**Horsley Drive Stage 2 - Building 1 (SSD-10404)  
Response to Submissions**

## **Attachment 1**

DRAWING TITLE
FINISHED LEVELS PLAN
SHEET 1
DRAWING No: Co114.92.18- DA51

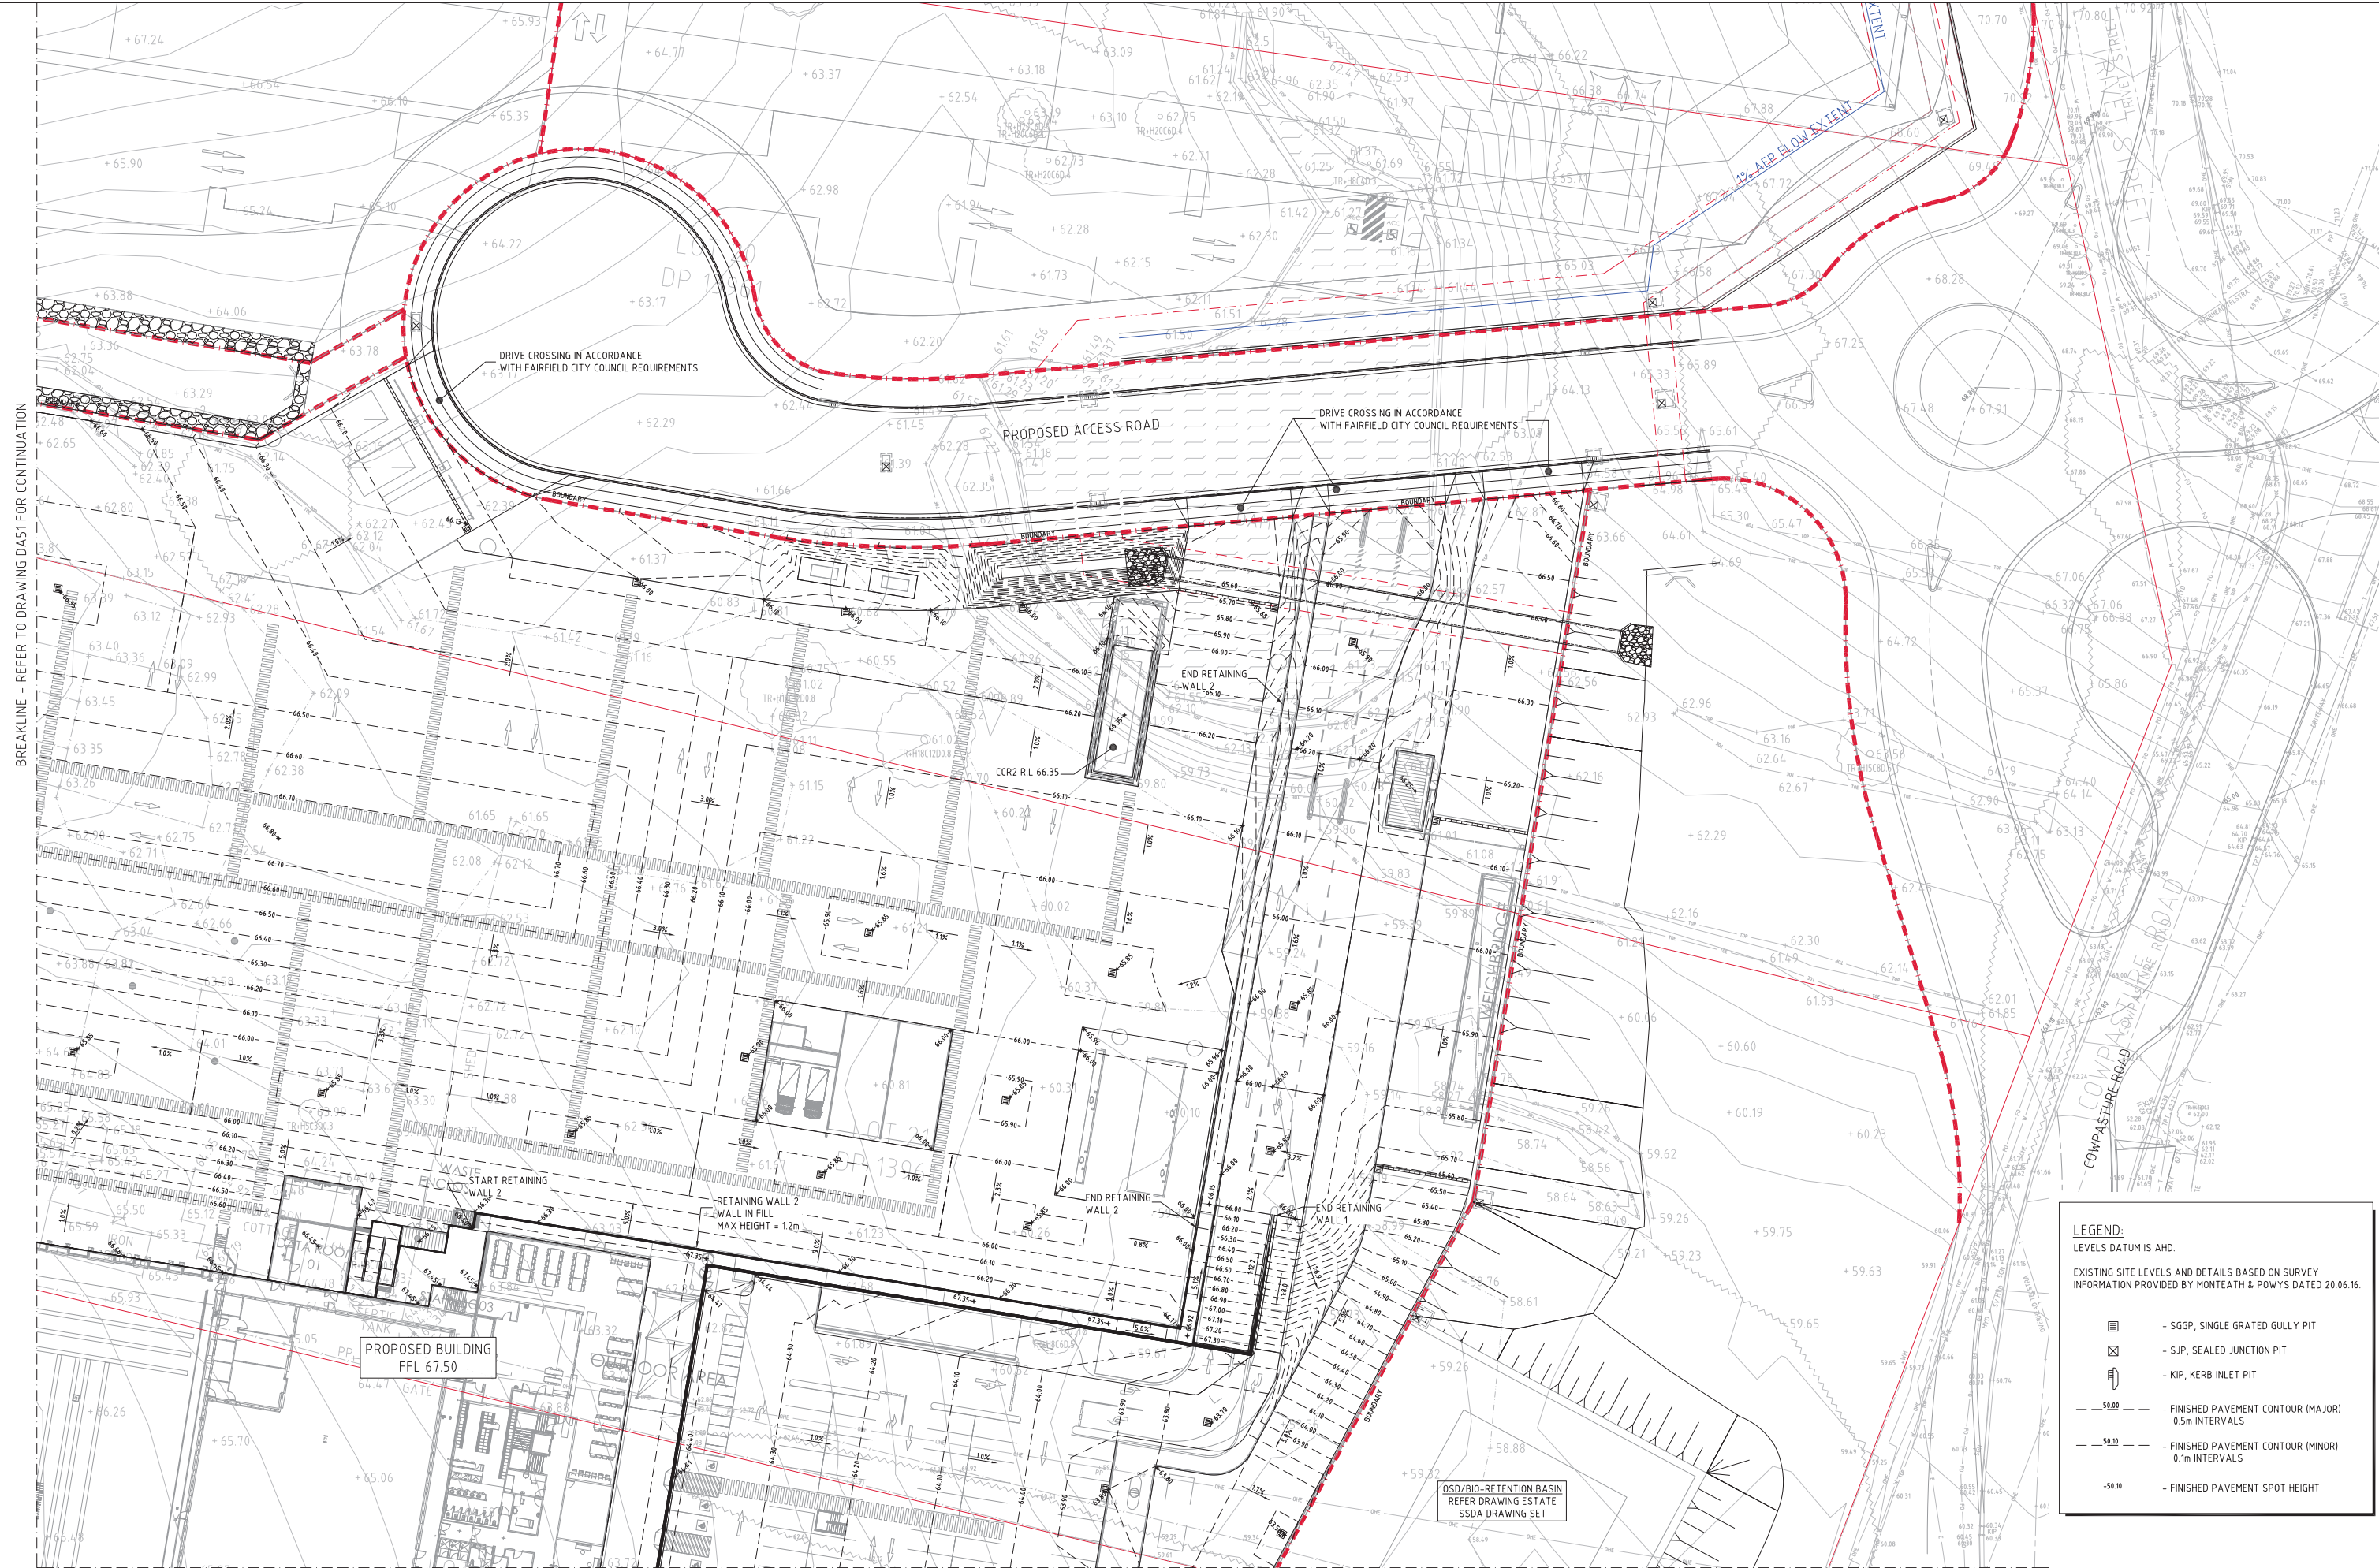
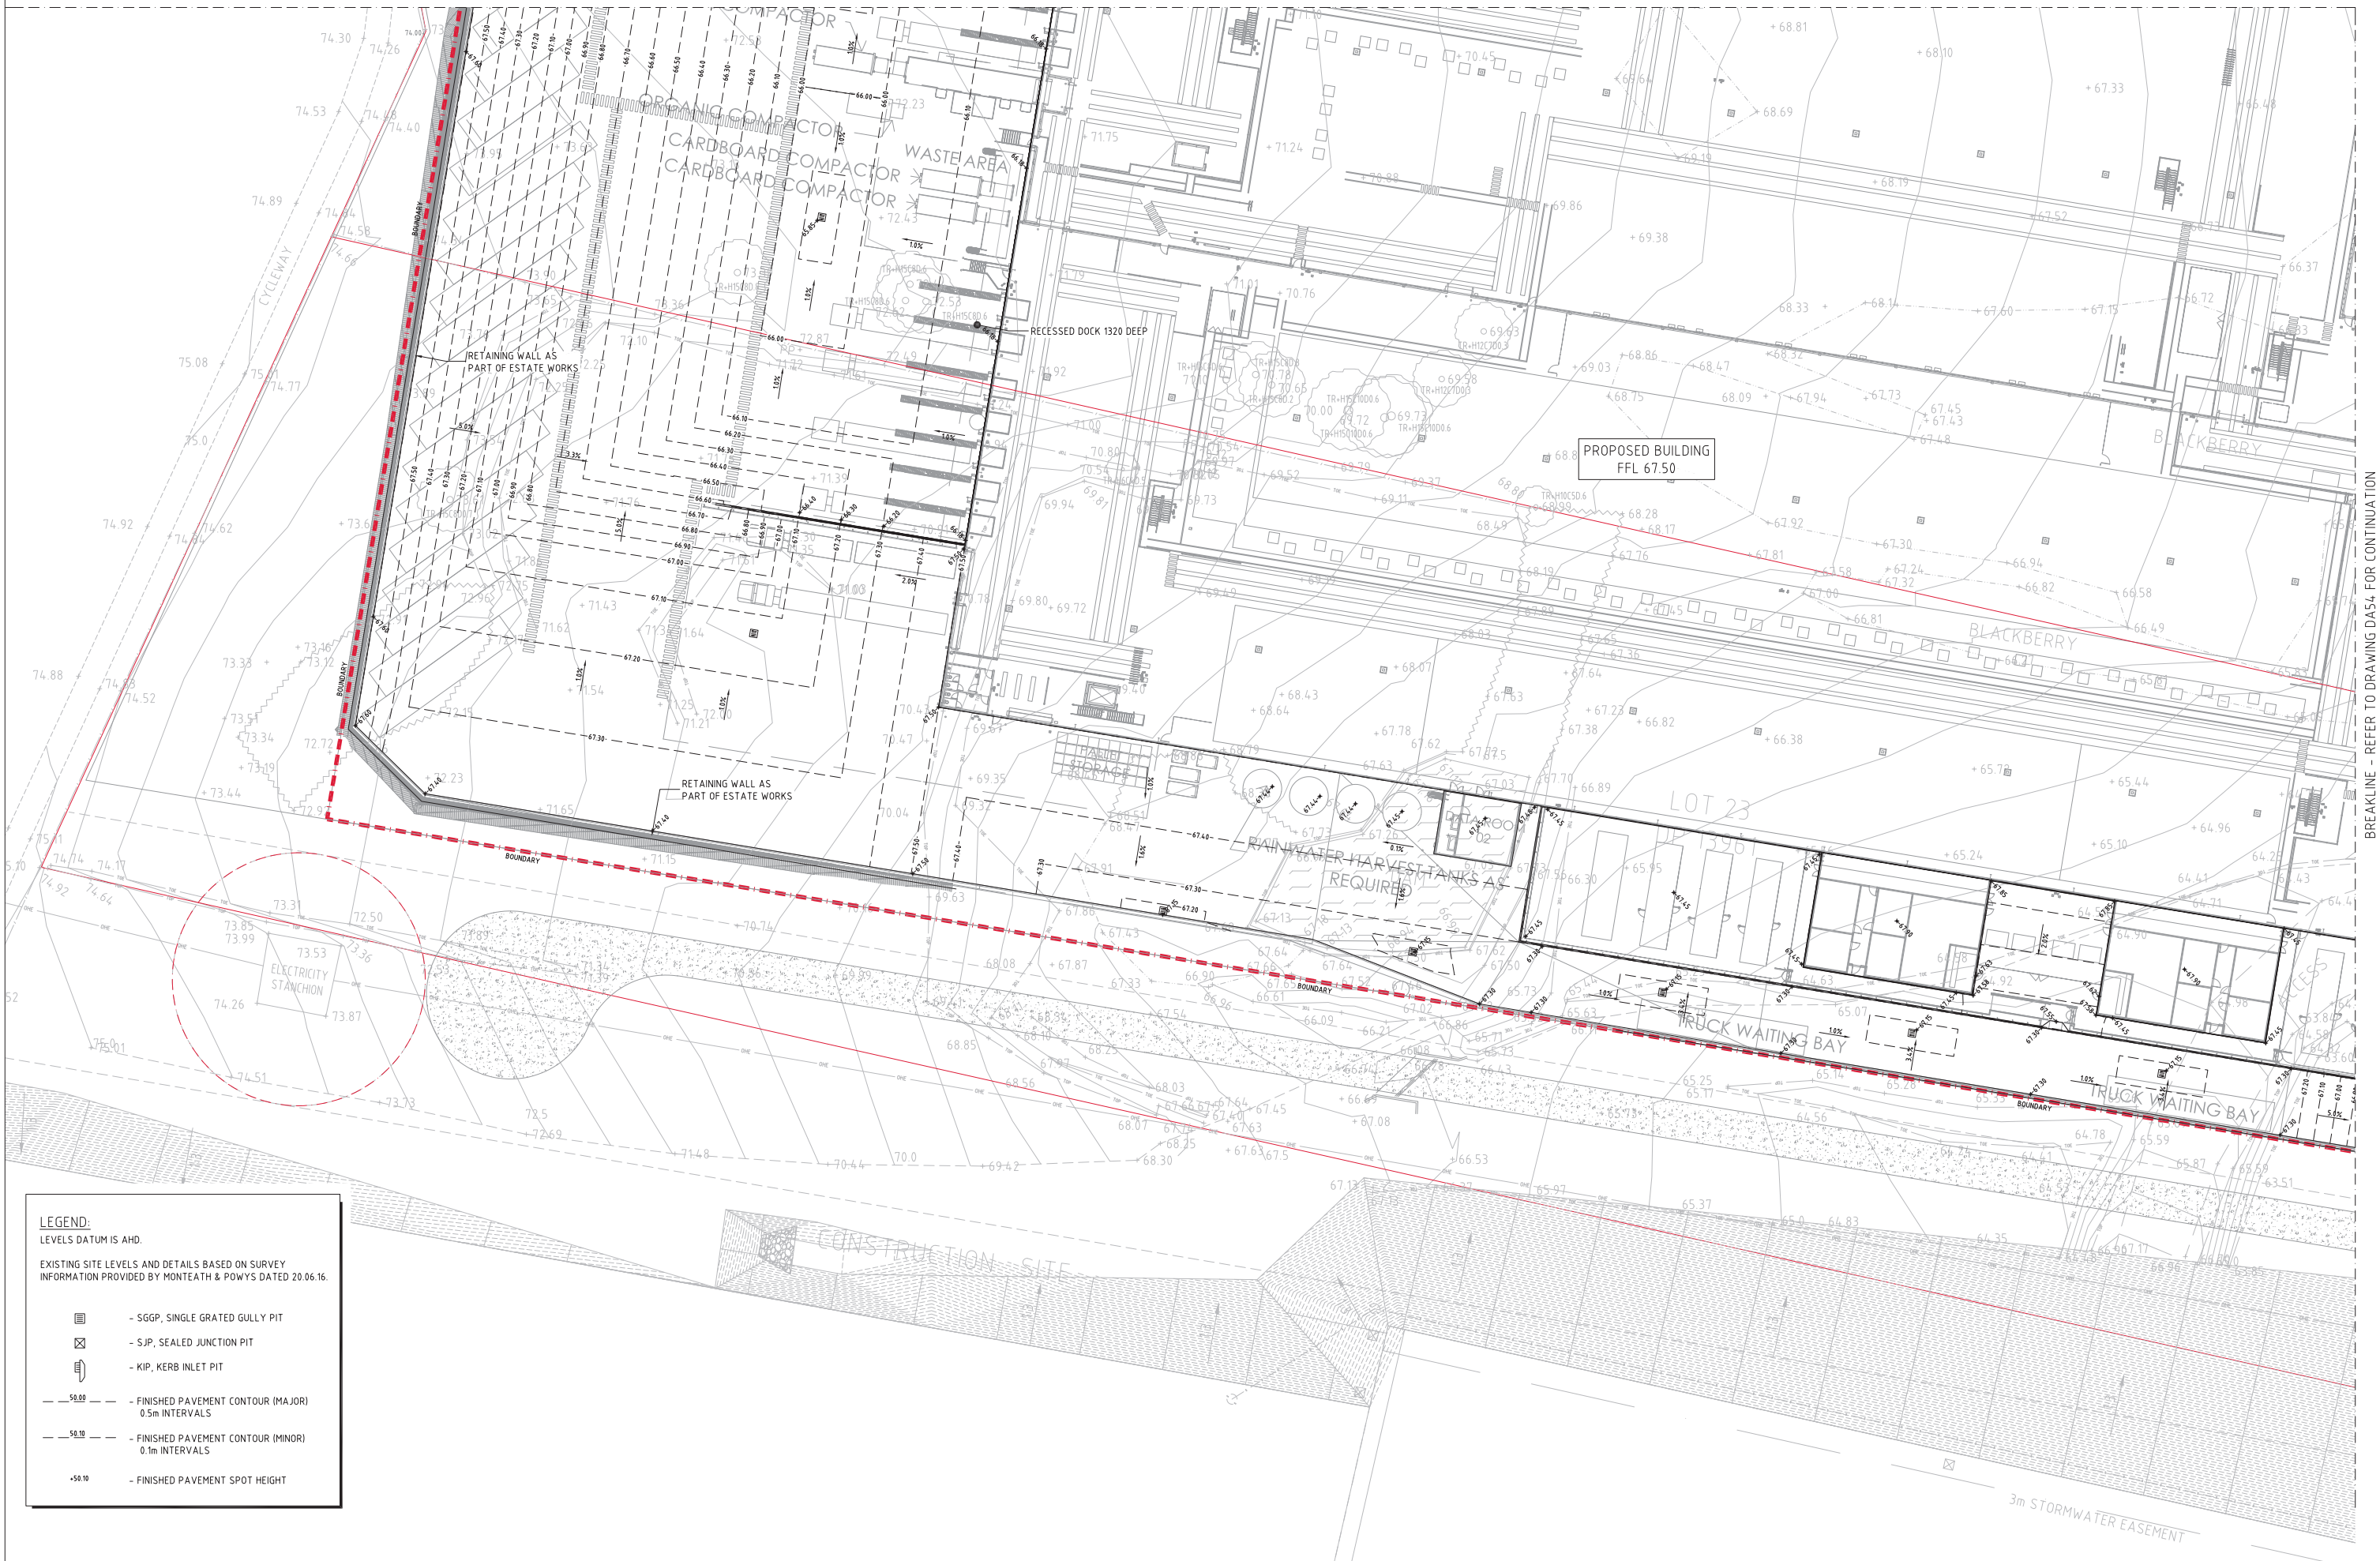
10. no details or plans showing the extent of the cut and fill requirements of the development (including batters or retaining walls) have been provided, including an absence to any references to natural ground levels, approved surface levels, or to be approved surface levels on any of the elevations or section drawings. This level of information should be provided, including a cut / fill heat map.
